From: Kipling, Sam [mailto:SAM.KIPLING@environment-agency.gov.uk]
Sent: 21 May 2015 06:05
To: White Rose CCS
Subject: EA Representations - 10030429

Our ref: RA/2015/131206/02-L01
Your ref: EN10048
Our ID: 10030429
Date: 20 May 2015

WRITTEN REPRESENTATION

THE WHITE ROSE CCS (GENERATING STATION) DEVELOPMENT CONSENT ORDER. LAND WITHIN AND ADJACENT TO THE DRAX POWER STATION SITE, DRAX, NEAR SELBY, NORTH YORKSHIRE.

Figure 1 Landscape and ecology mitigation plan

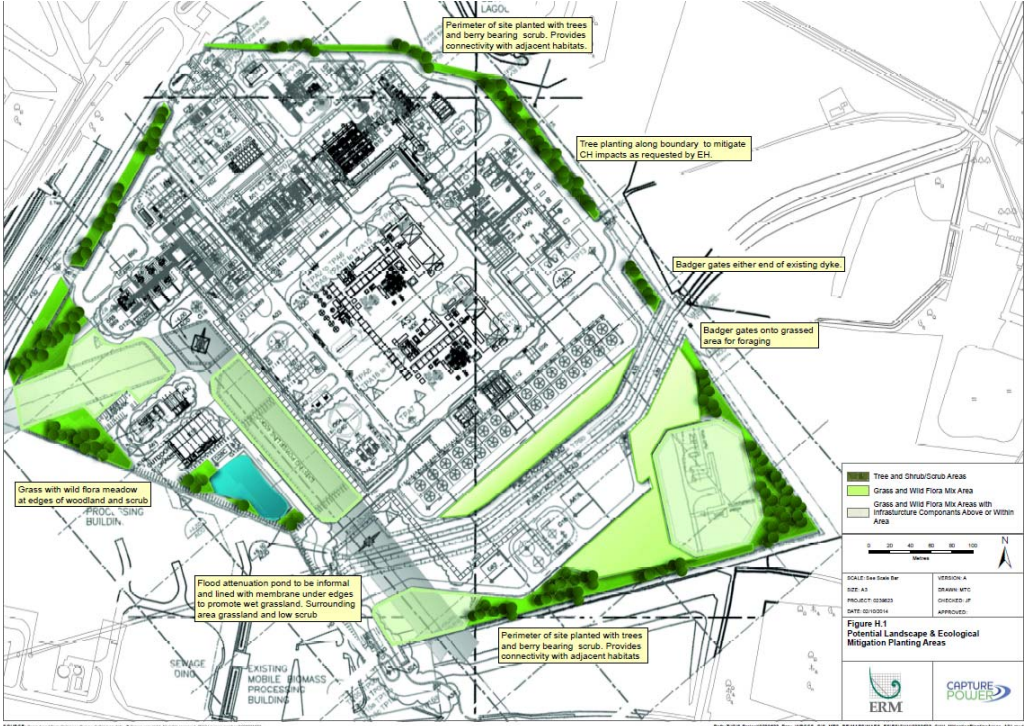
3.3 Amongst other losses, the memo confirms the permanent loss of ~1.48ha of pond and swamp as well as the temporary loss of ~0.18ha of pond. The memo describes that this will be mitigated for through the provision of a multi-functional attenuation/biodiversity pond (see our response to first written questions) of ~0.22ha. The memo acknowledges however, that there is a deficit in mitigation of ~1.26ha which is, as yet, unaddressed. This figure also assumes that the applicant will be able to adequately demonstrate that the proposed attenuation/biodiversity pond can be relied upon as biodiversity mitigation.

3.4 The issue of habitat loss and the need for adequate mitigation or compensation/offsetting has not been satisfactorily addressed through the application and, given this new information, we do not feel it is appropriate to defer this issue for resolution through Requirement 16. We request that the applicant provides evidence that the impacts of the scheme can be adequately mitigated, compensated for, or offset - in line with the Defra 2012 offsetting methodology.
